ENG-SF21021-R2-CDs.pdf Markup Summary

RETREAT AT TIMBERRIDGE FILING NO. 2
CONSTRUCTION PLANS
GRADING & EROSION CONTROL PLAN

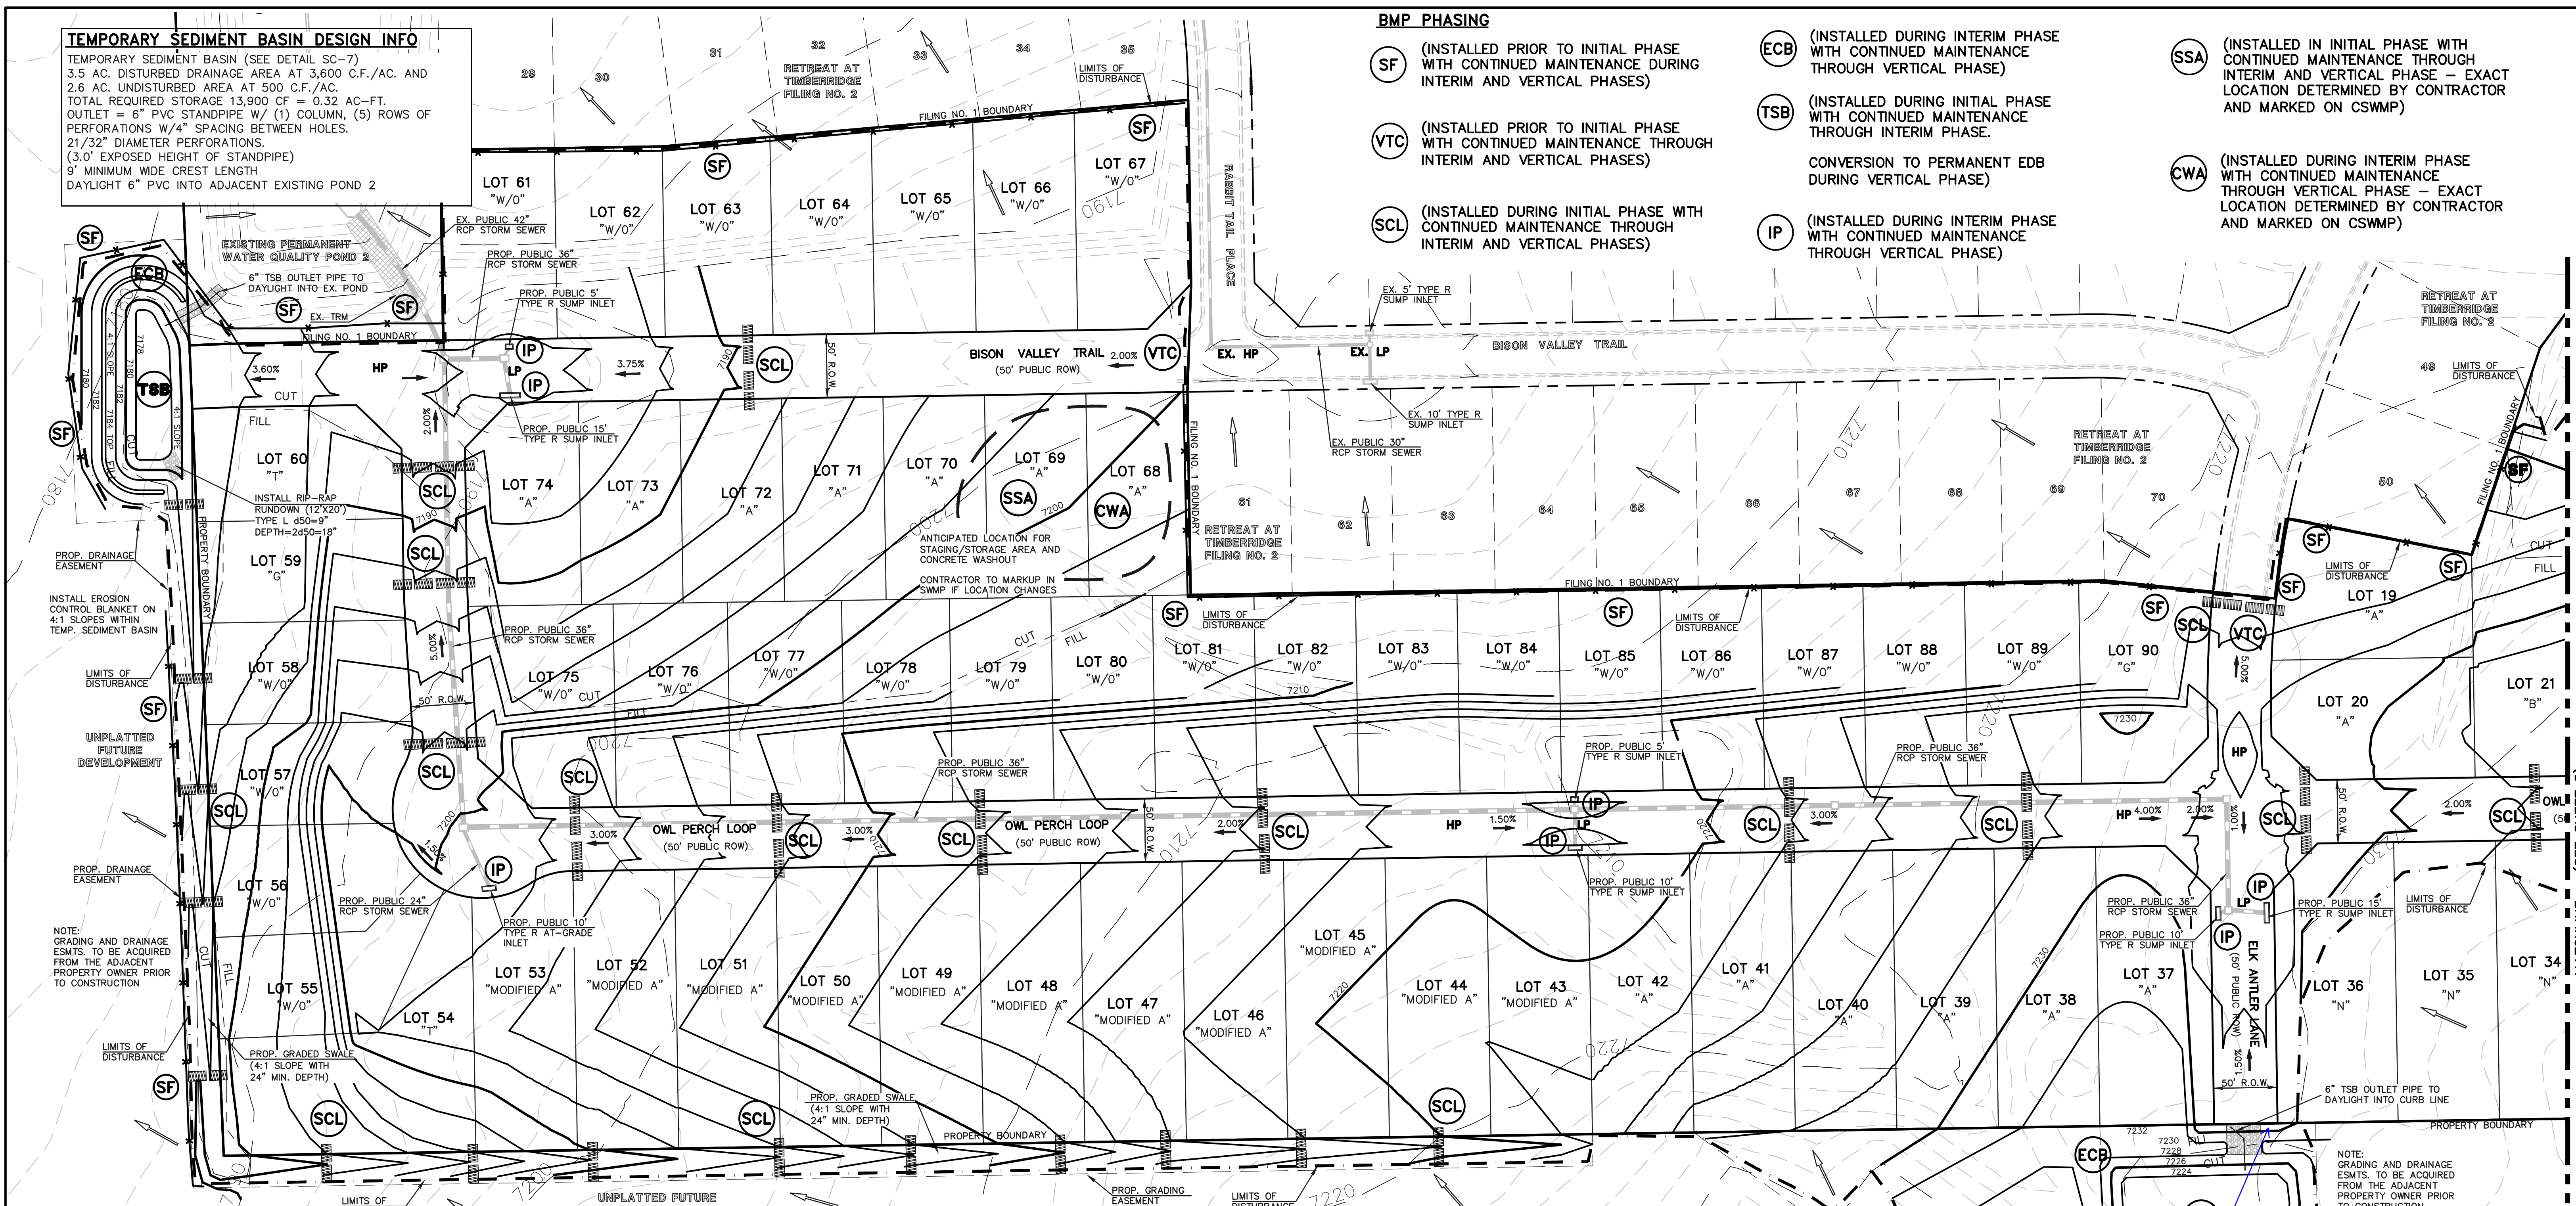
Missing culvert

we have been seeing a lot of blow outs when using straw bales in ditches after a large rain event. consider using straw wattles in lieu of straw bales.

add temporary sediment basin to treat stormwater during construction.

add temporary sediment basin to treat stormwater during construction.

Provide VTC or construction fencing, barricades, and/or signage at access point. GEC Checklist Item W

If "limits of disturbance" and "construction boundary" are the same, change to "limits of construction/disturbance" or otherwise show as separate line types for each on the legend and figure. GEC Checklist Item H

Label the grade control

2% bench per std section? (if not needed add a note on the std. section sheet.

If the 2% bench is for walking, do you want to go around the hole?

label as maintenance access also or show that

clearly show all maintenance access roads

Additional check structure?

rock check dams?

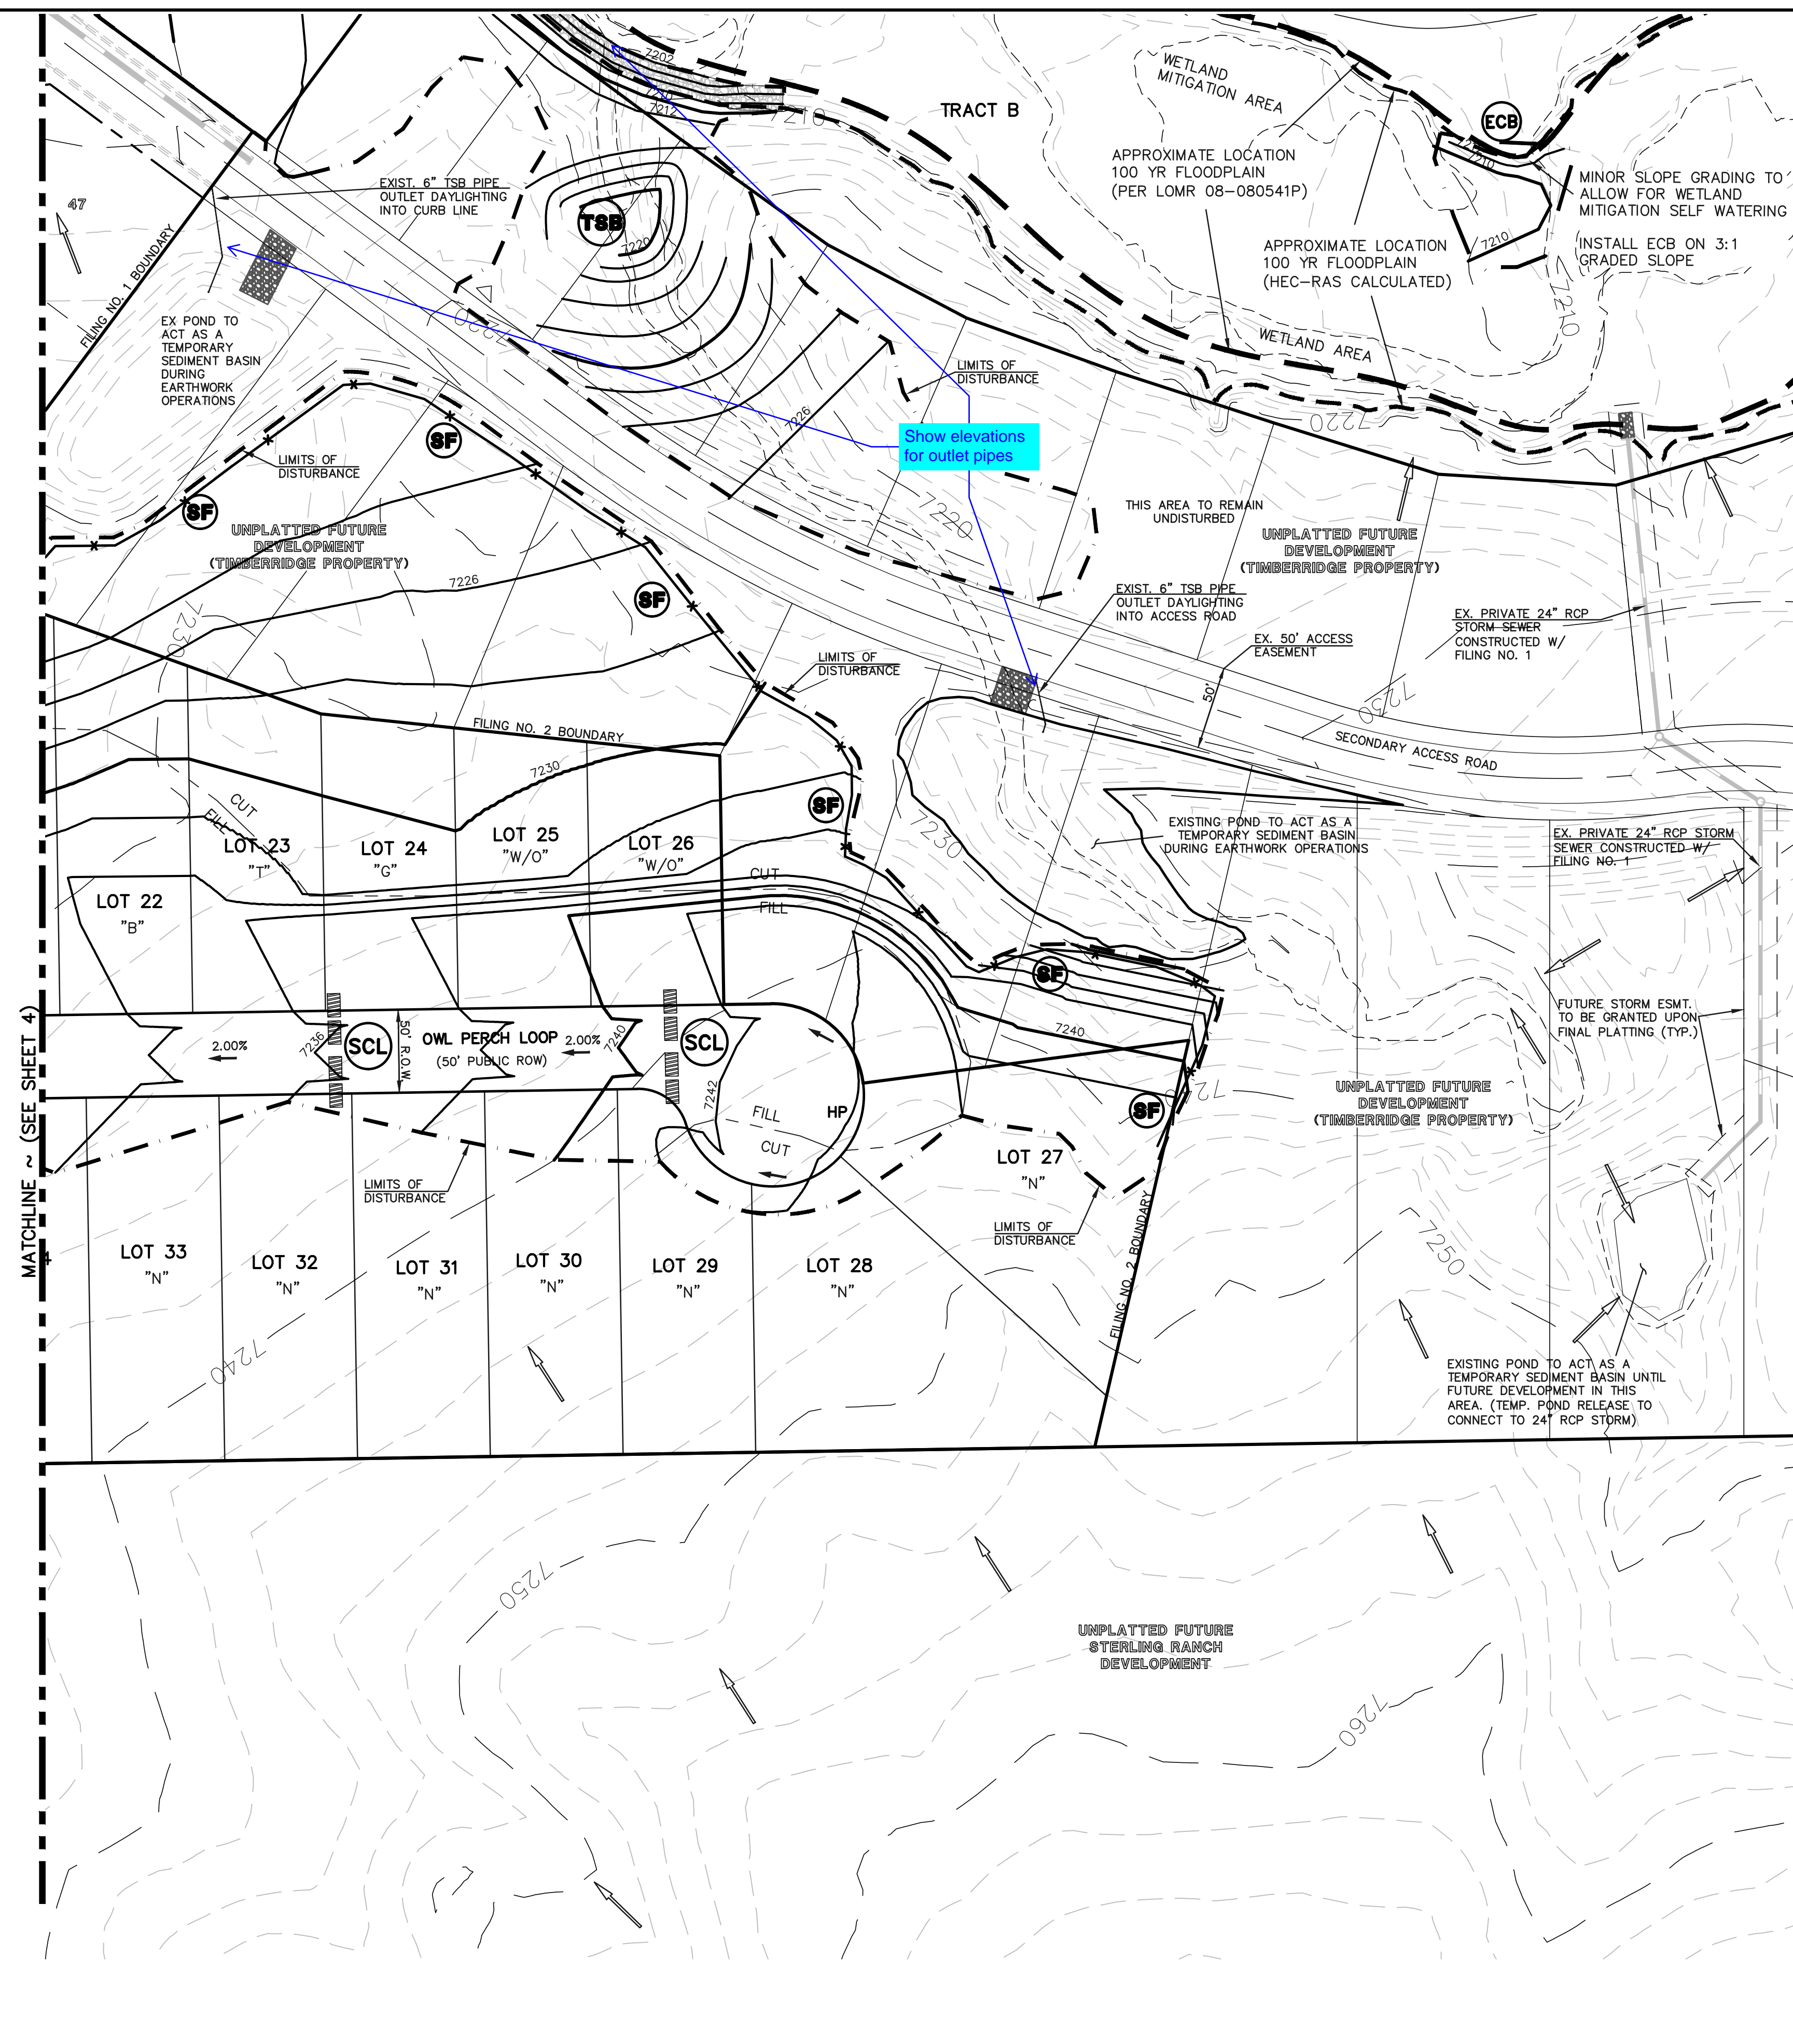
Show where the temporary and permanent outlet pipes will release flows (into an inlet?). Curbline appears to be 5' higher than the pond bottom.

Provide swale cross-sections and design

show rundown protection

RETREAT AT TIMBERRIDGE FILING NO. 2
CONSTRUCTION PLANS
STORM SEWER PLAN

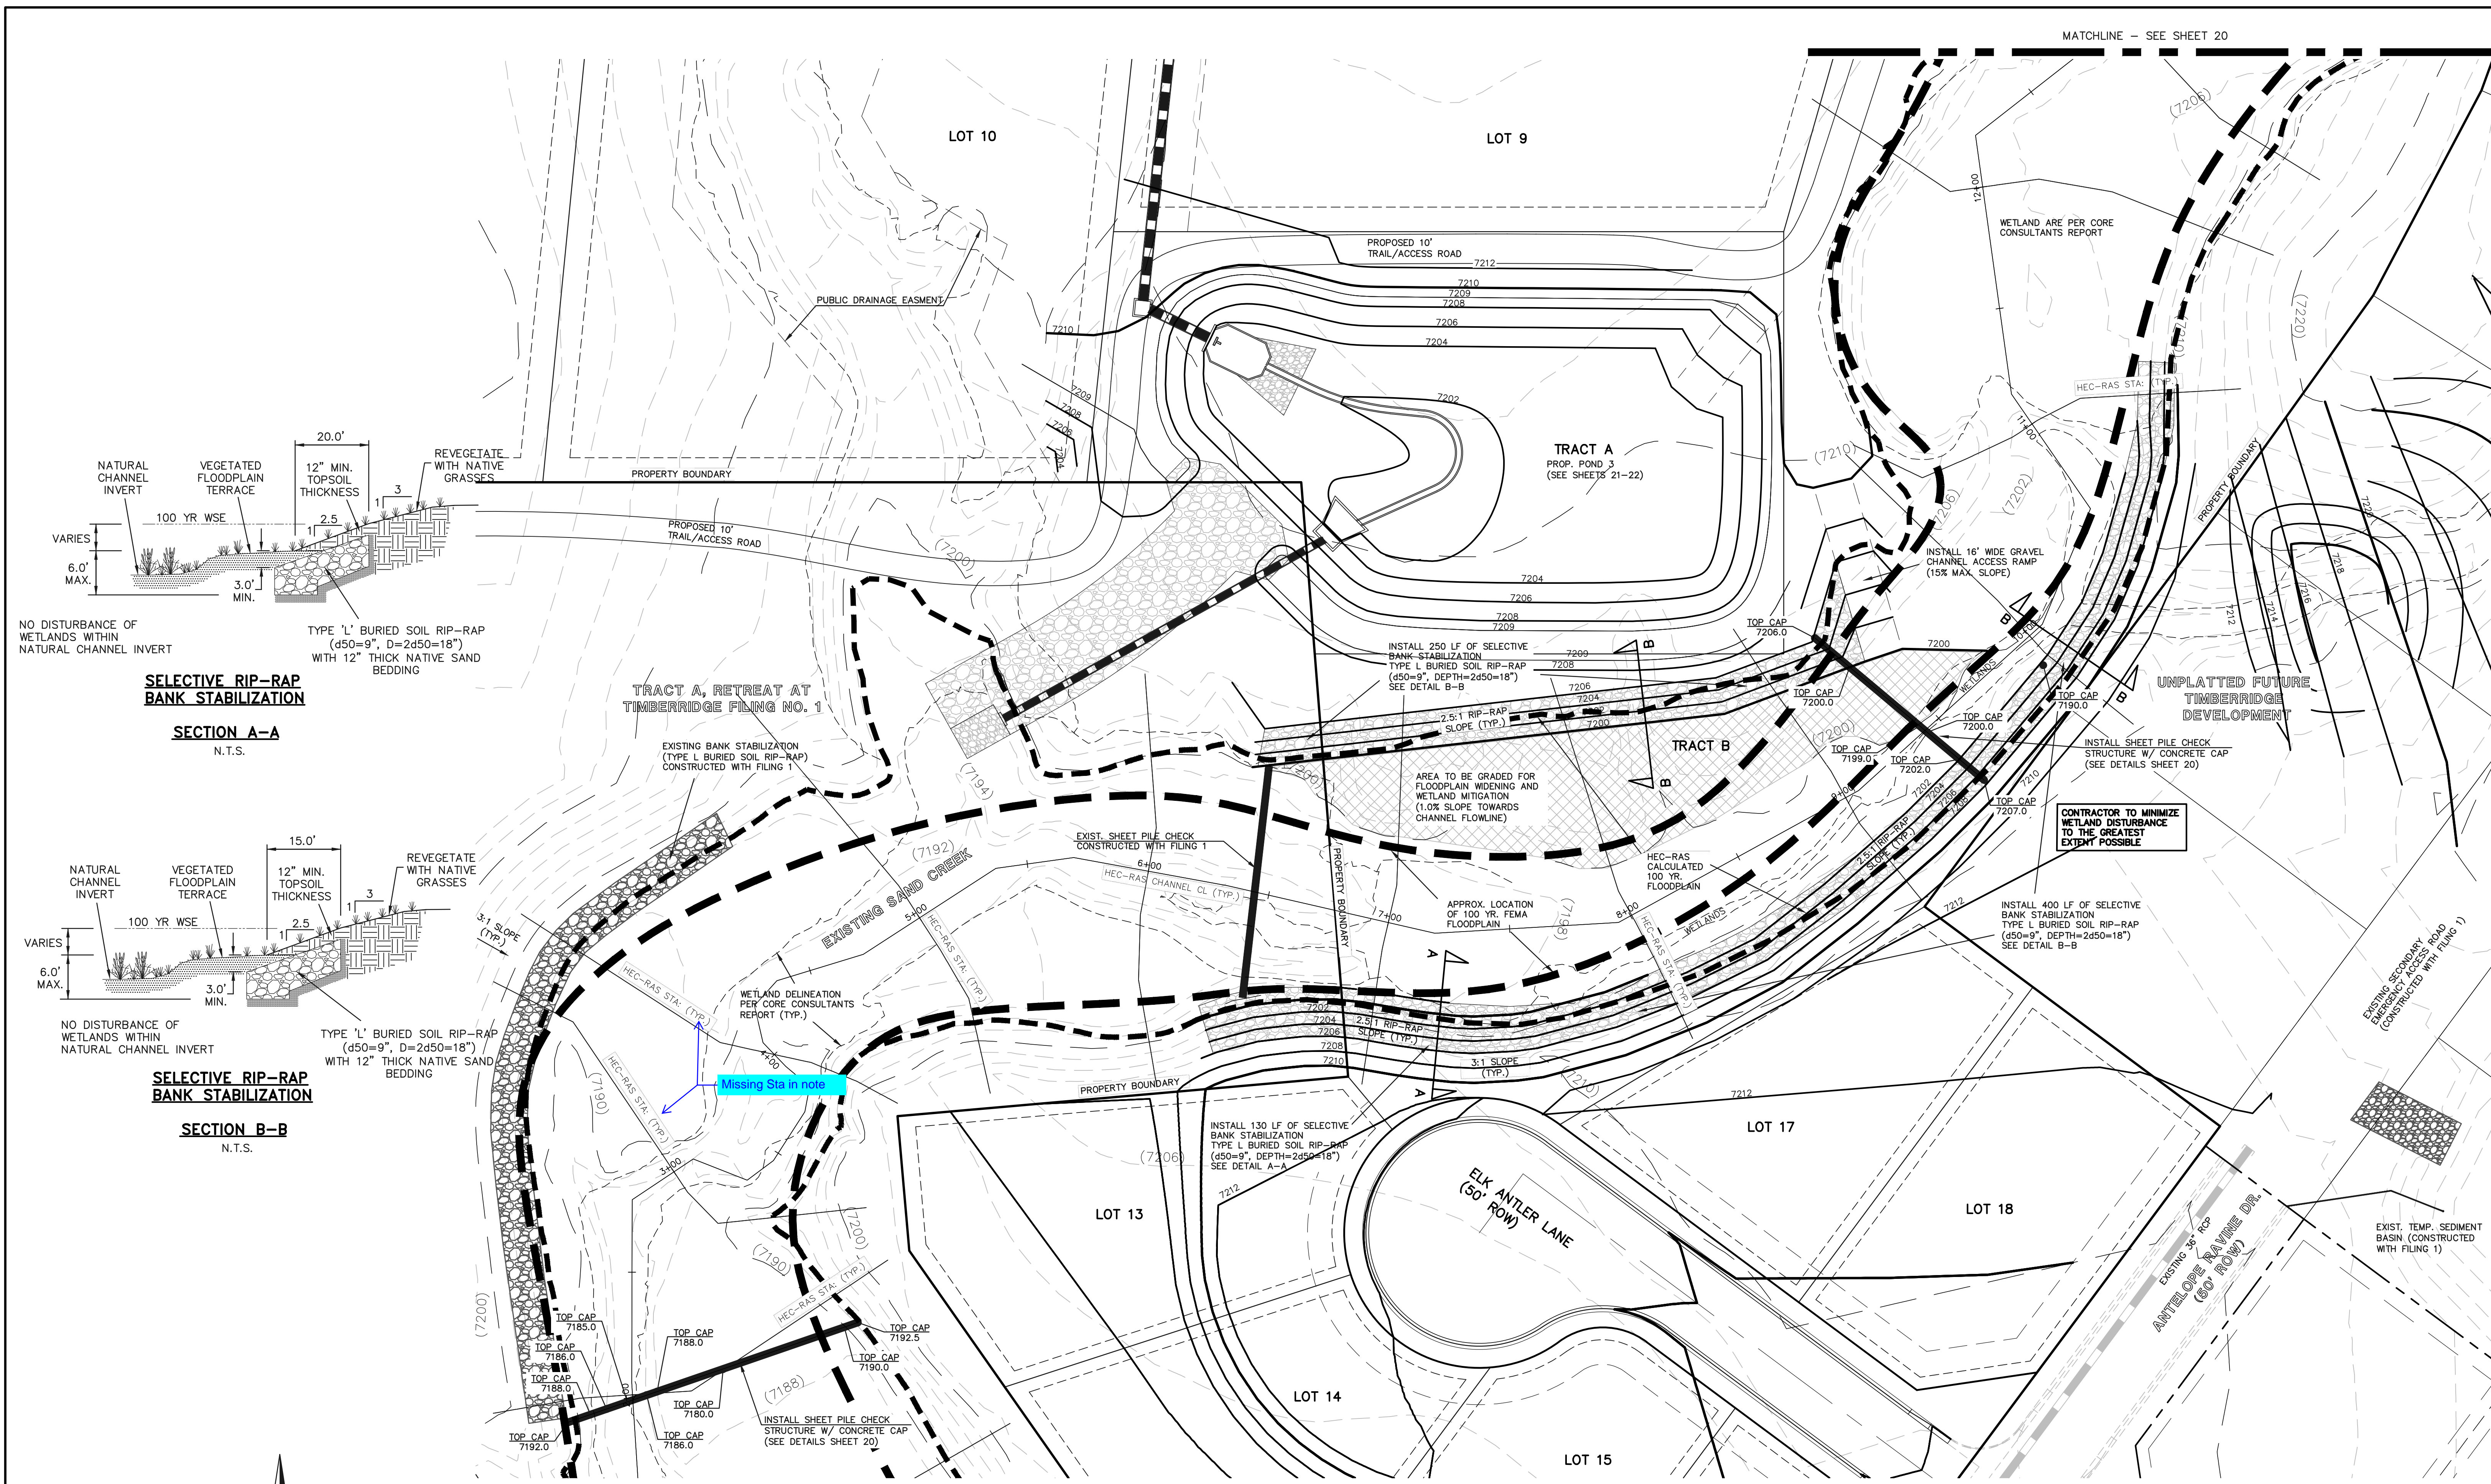
Per Grade line summary in FDR HGL is 7223.05

Show 100-year water surface

Show ponding limits within drainage easement
